Rezoning Transportation Analysis

Petition Number: 2020-035

General Location Identifier: Tax ID 04711201

Date	Description
03-25-20	First Review
04-23-20	Second Review
06-25-20	Third Review (KP)
08-25-20	Fourth Review

Drawing file: revised-site-plans / 2020_035_revsiteplan_2020_08_17.pdf

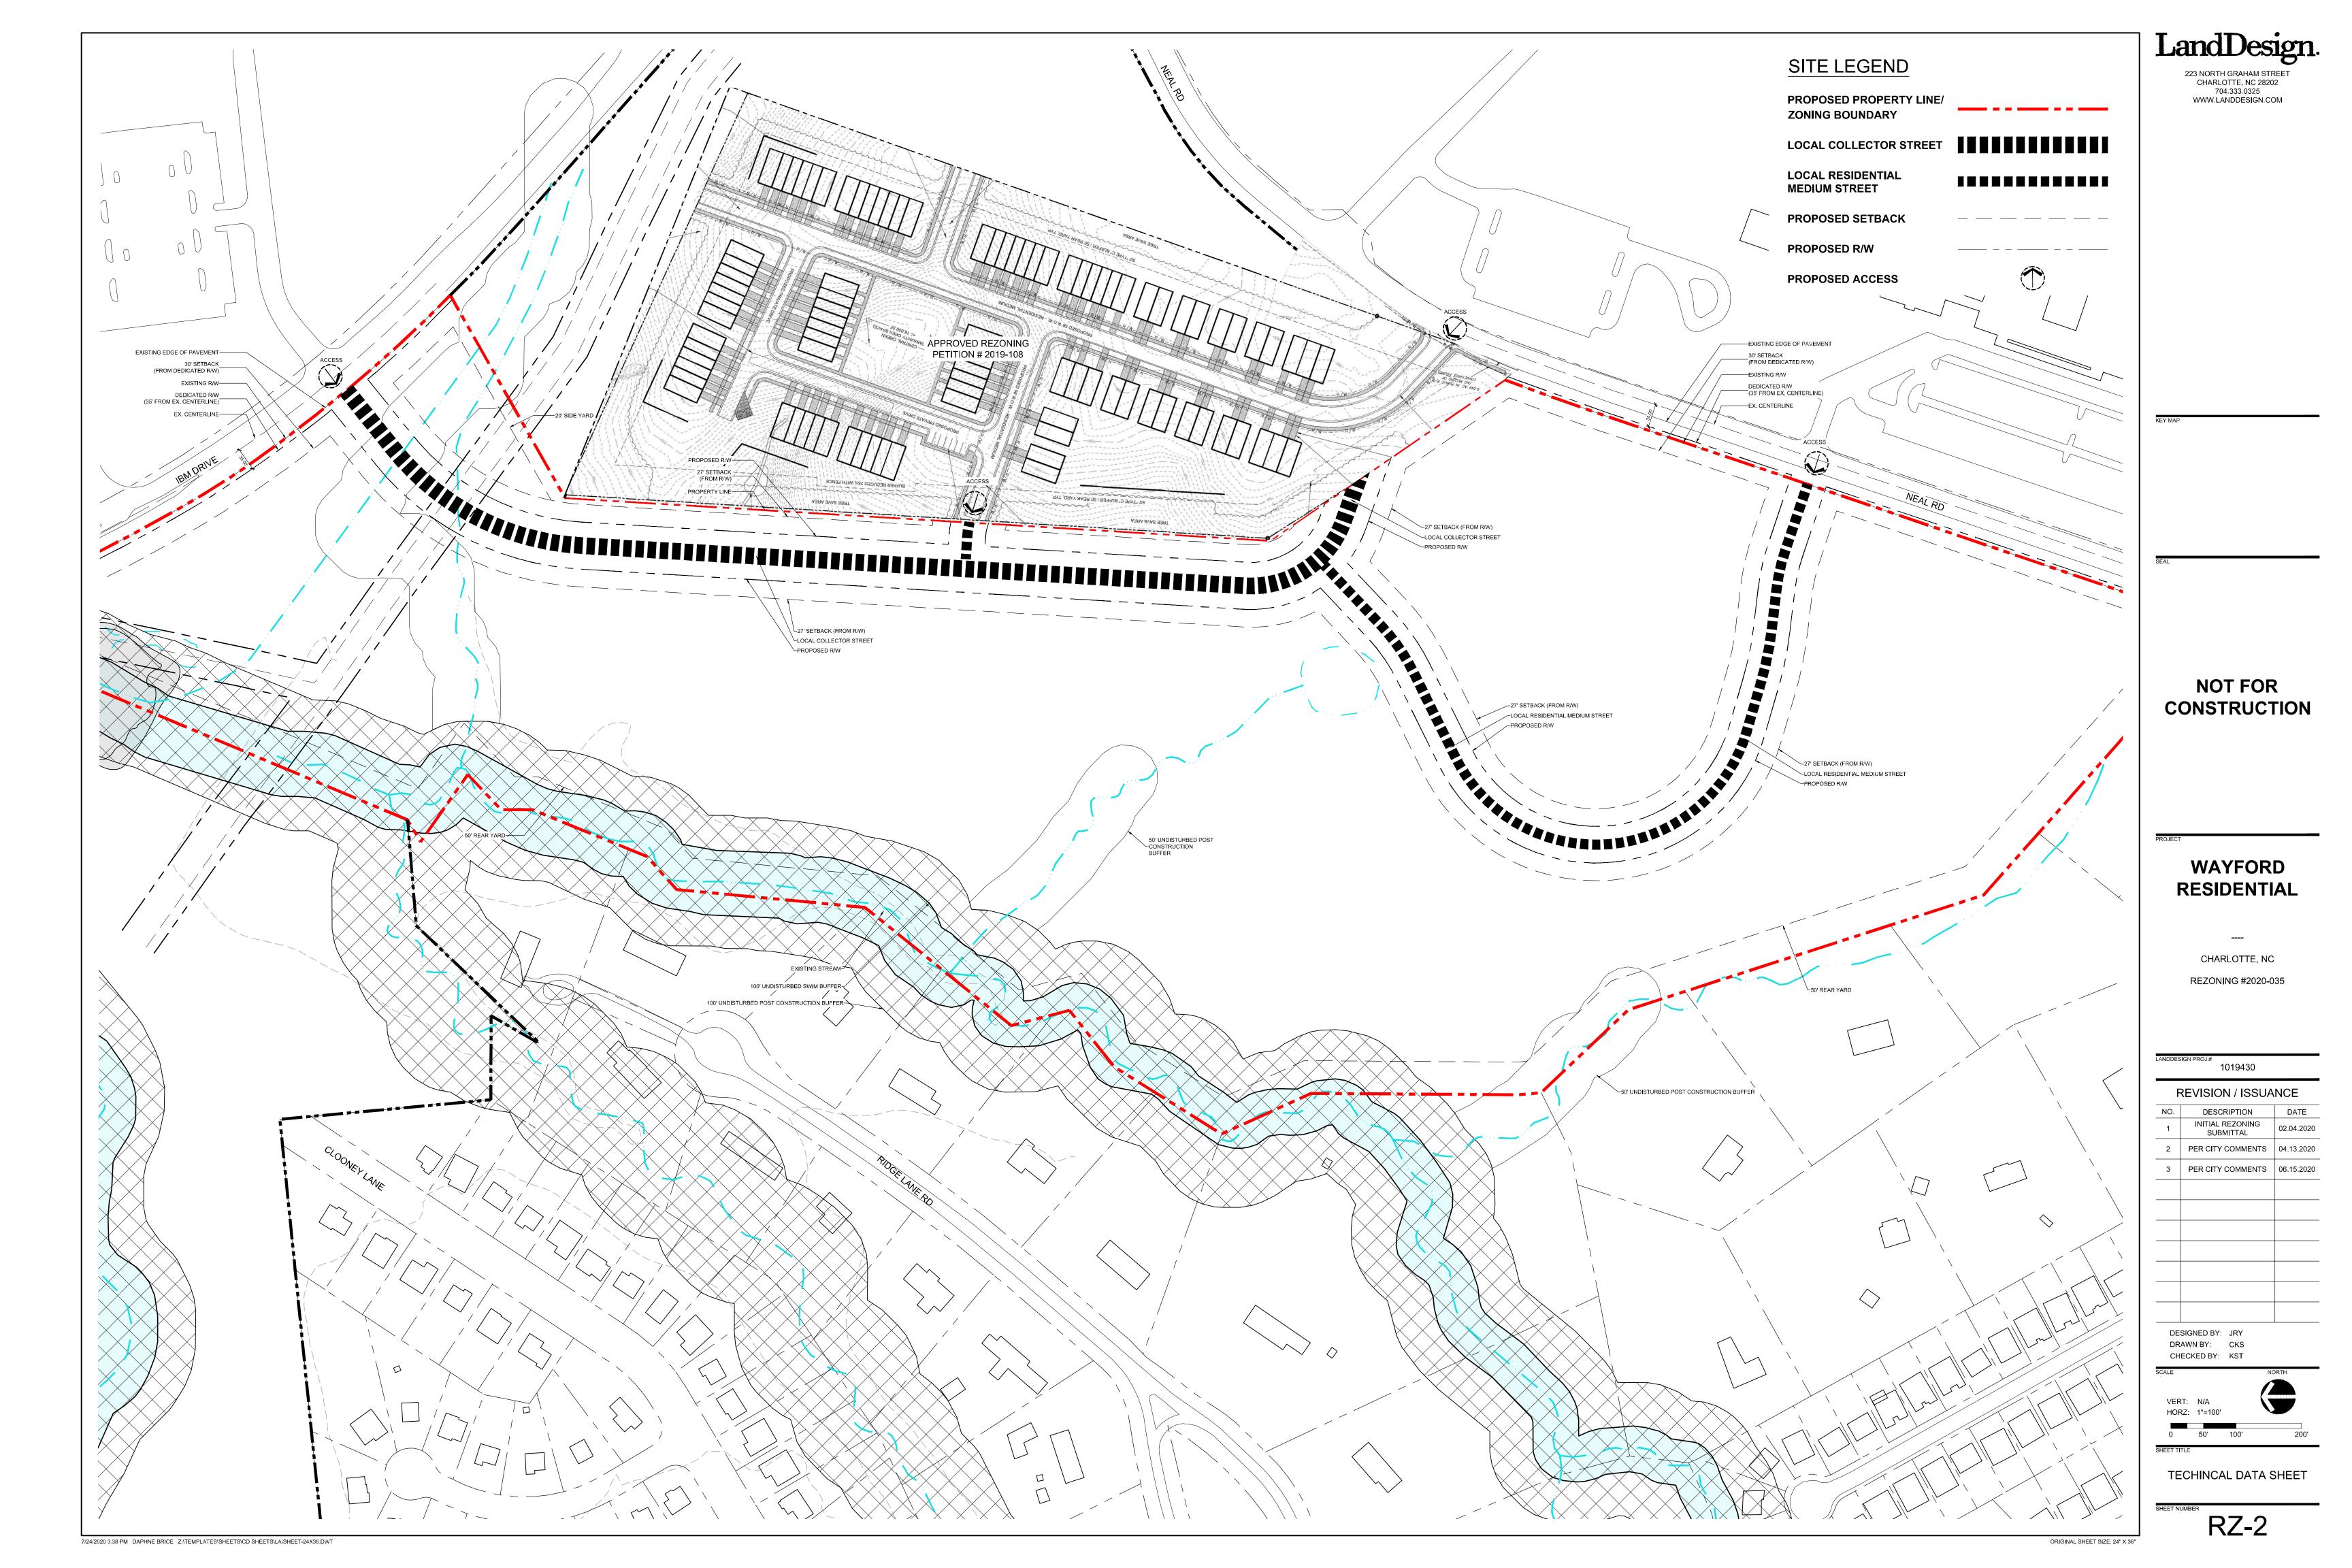
- i. **New comment (site plan dated 8-17-20)** The petitioner should include rezoning petition 2020-102's street network within the revised plan, to coordinate tie-in points.

- b. **Outstanding comment** The petitioner needs to provide an existing queuing analysis for the school driveways on Neal Road to fully understand the traffic situation and to adequately locate the driveways.

- a. **New comment (site plan dated 8-17-20)** The petitioner should revise the site plan and conditional note(s) to revise the 6-foot sidewalk to a 12-foot multi-use path, in accordance with Charlotte BIKES, along Neal Road and IBM Drive, to tie-into the requested bike facility issued within rezoning petition 2020-102.
